## **UTS Central, Broadway Precinct**

University of Technology Sydney

### **Response to Submissions**

July 2016

Proposed 12:00PM SHADOW DIAGRAM - SEPTEMBER  
1:1000

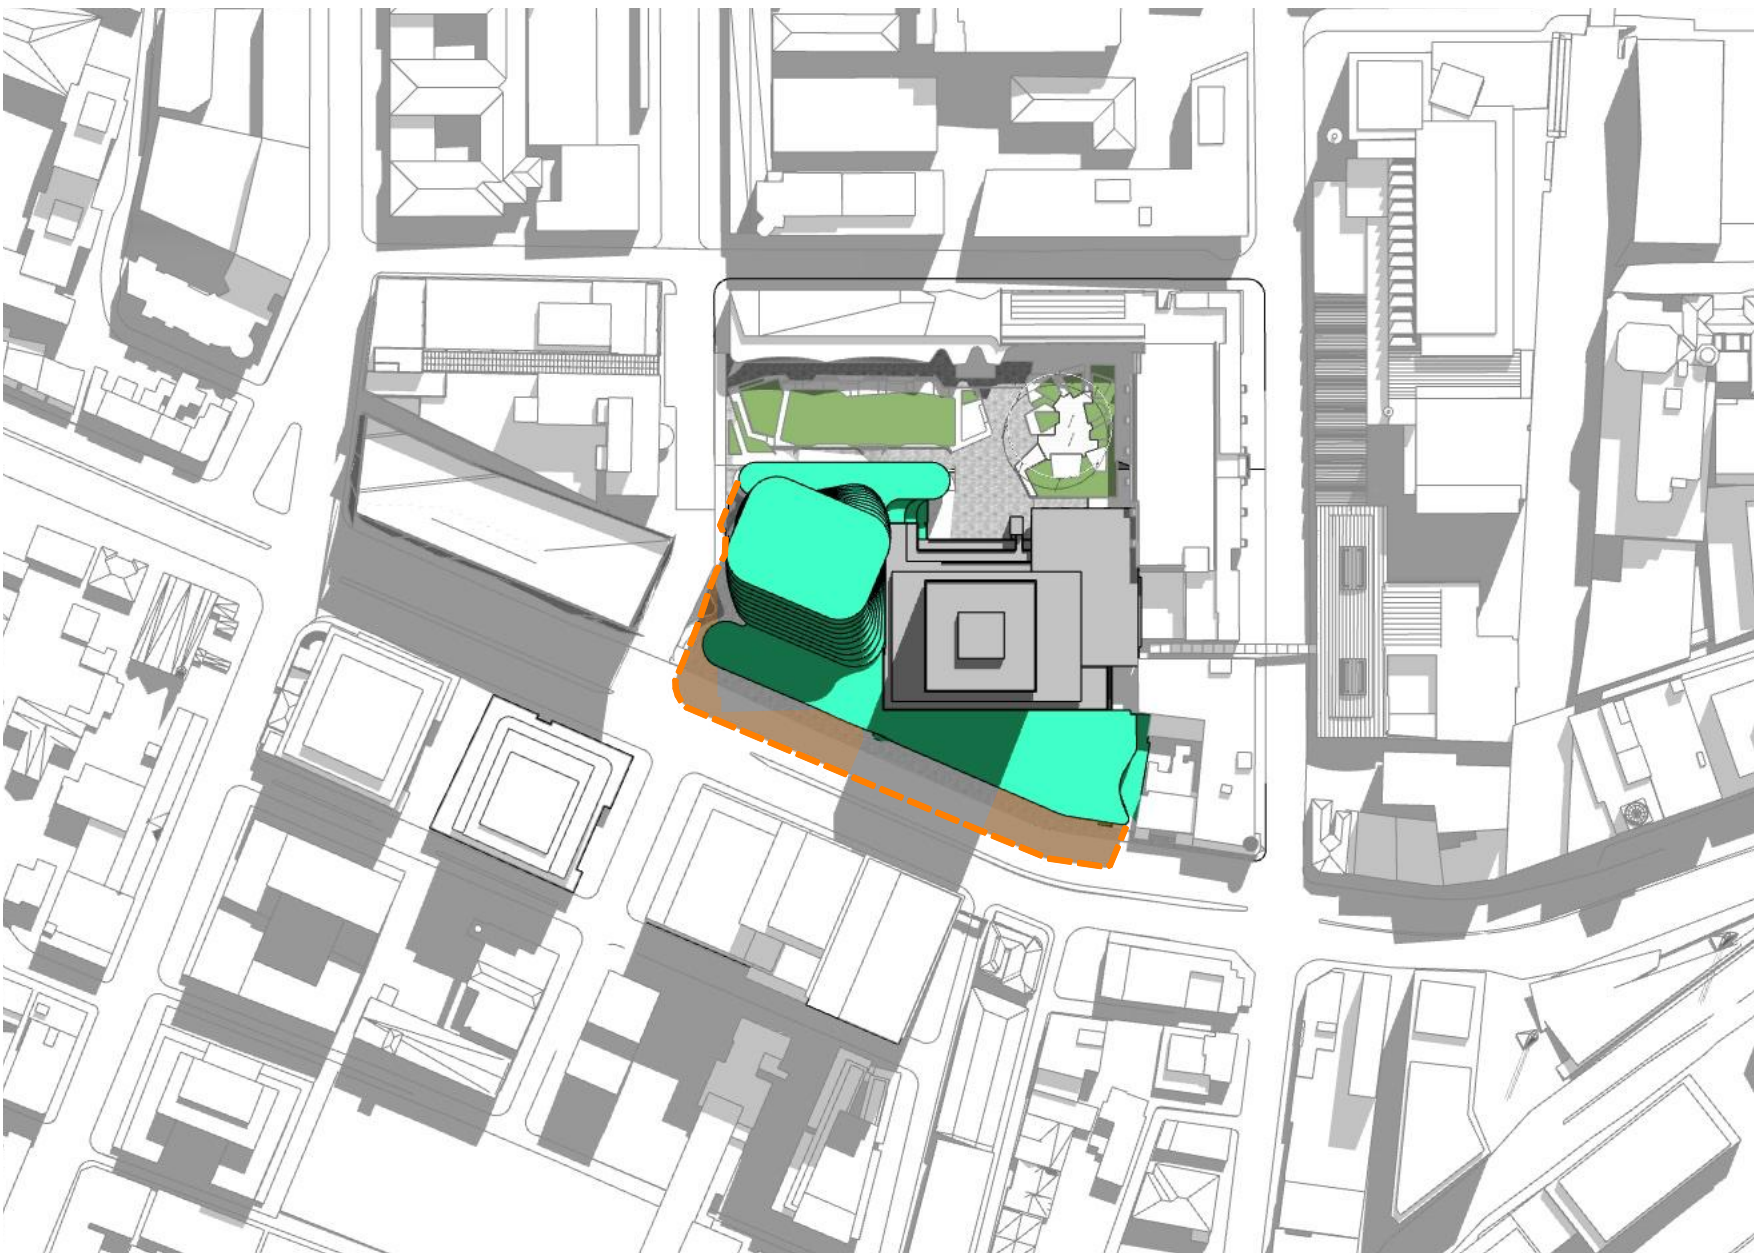
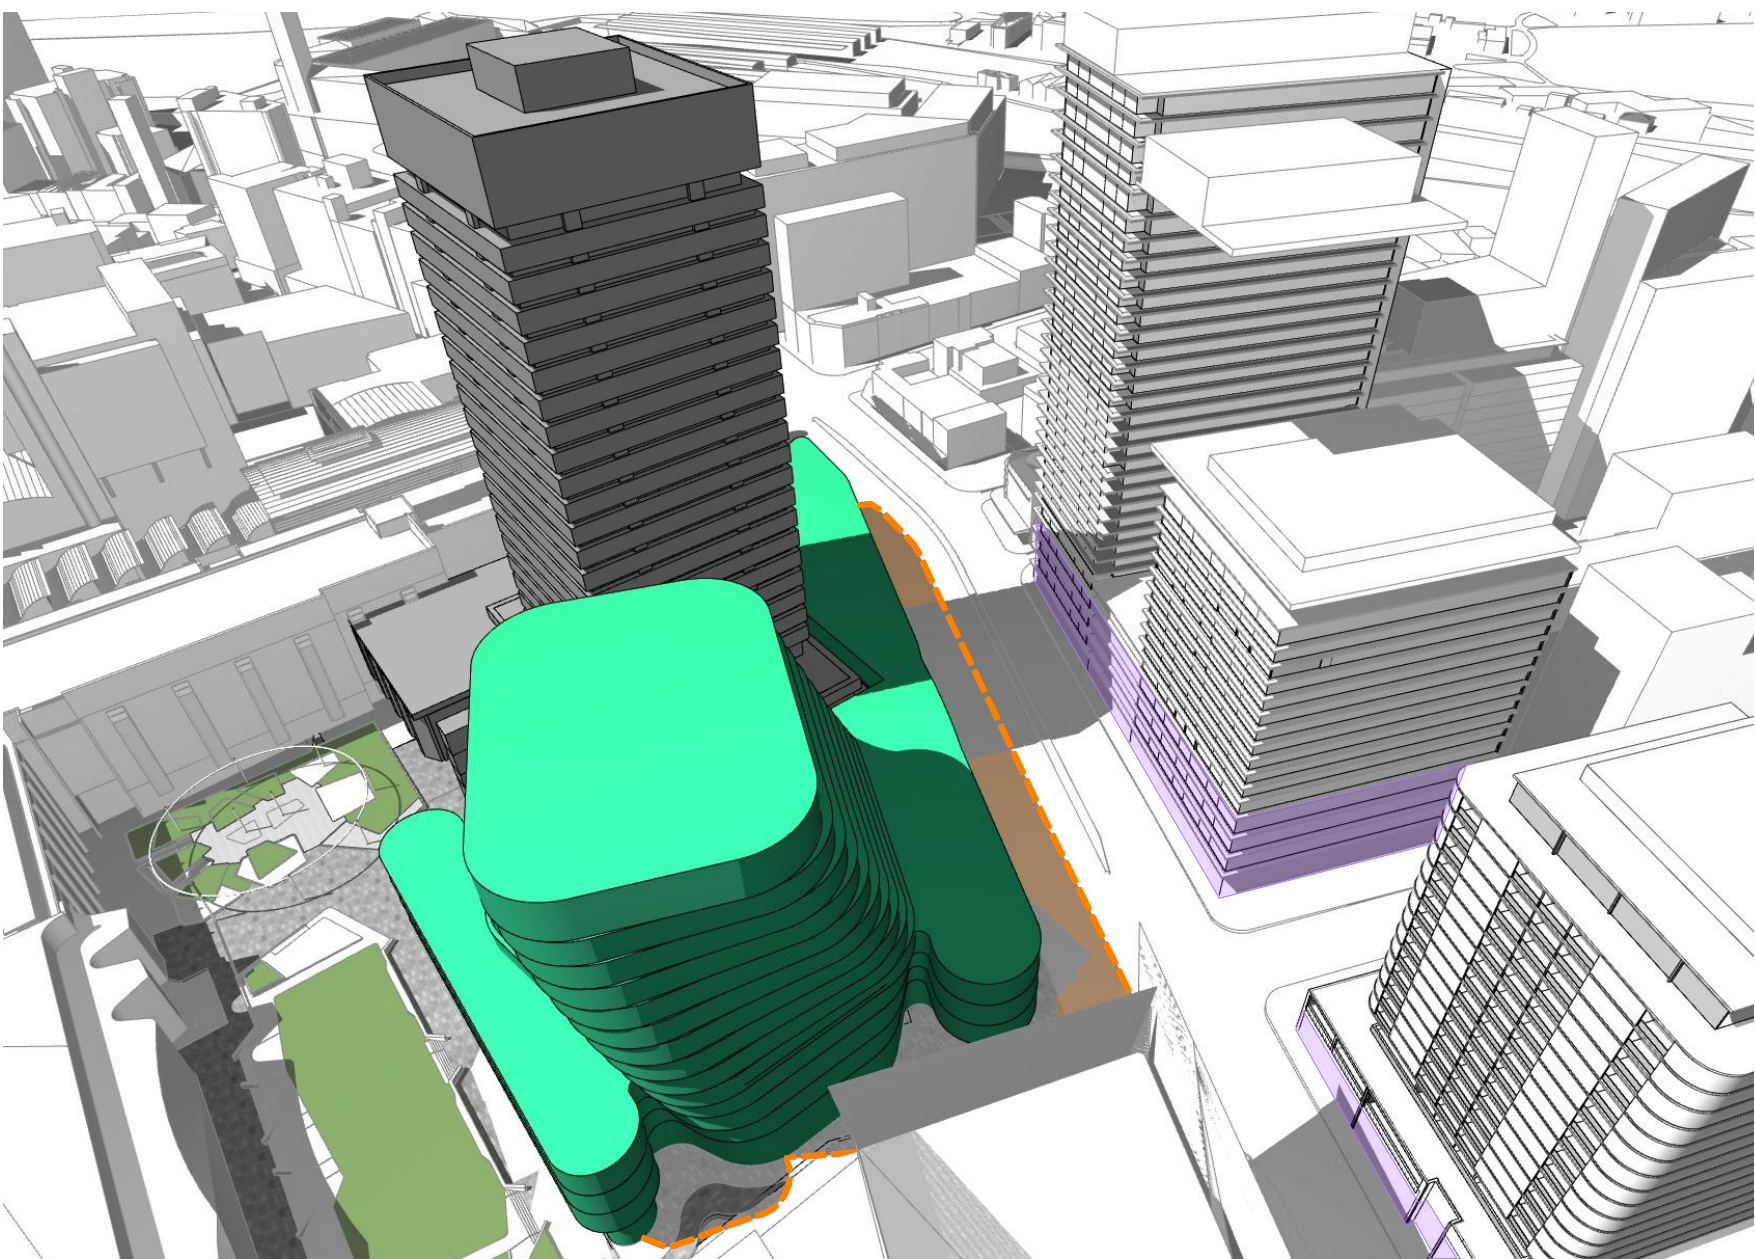
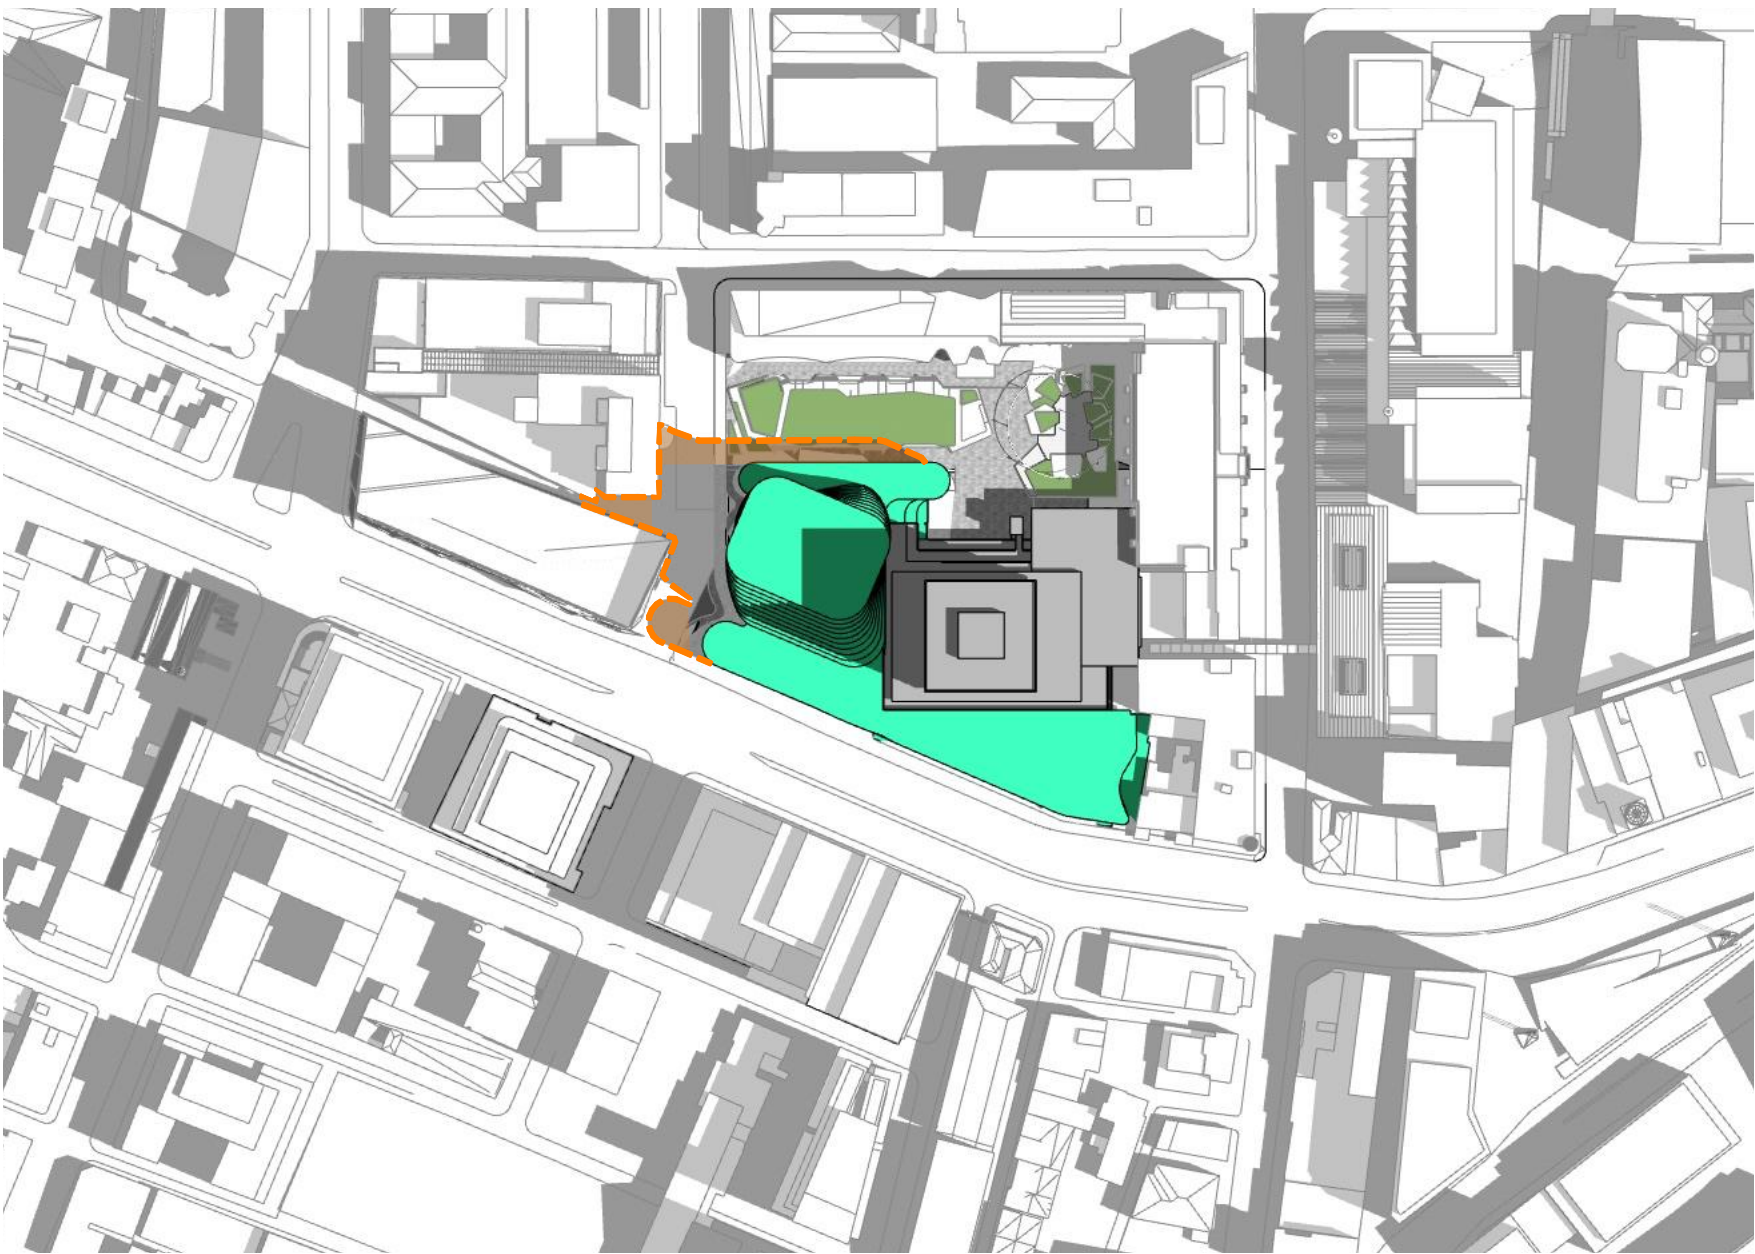
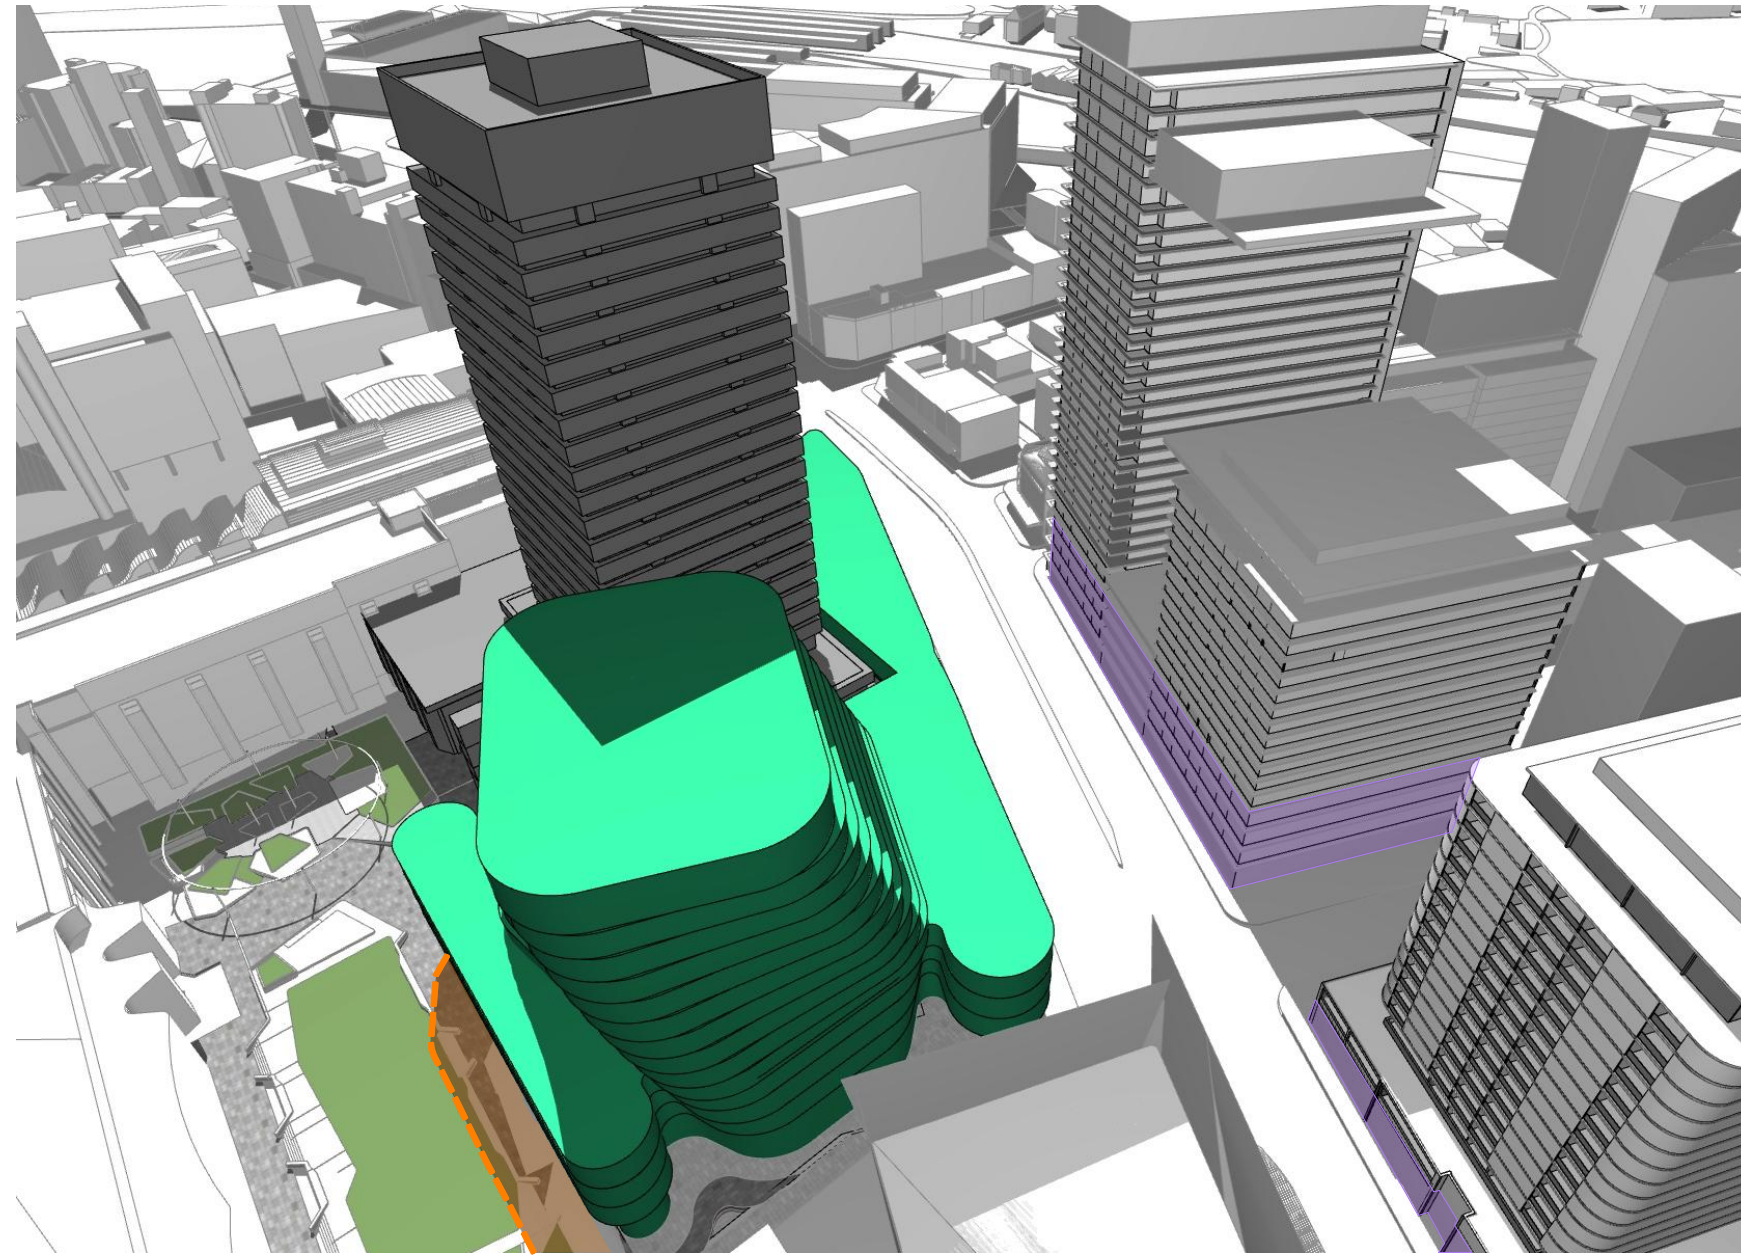
1. The Department is concerned with the overshadowing impacts from the proposed building on the residential properties within Central Park and a further quantitative analysis of solar access to be retained and lost for all

dwelling impacts by the proposal must be provided, including additional analysis of whether the proposal would impact on any heliostat solar collectors for building within Central Park.

- There has been further study and quantitative analysis of the shadow impacts from the proposed CB02 and podium extension on the residential properties within Central Park. The additional analysis that has been completed has been attached to this report. This has been done in conjunction with and is supplementary to the analysis already completed for the current DA submission.
- The proposed development is the same height as the lower tower of No. 1 Central Park and does not impact on the roof level of the lower tower where the reflectors are located or the roof level of the higher tower where the heliostat is located.
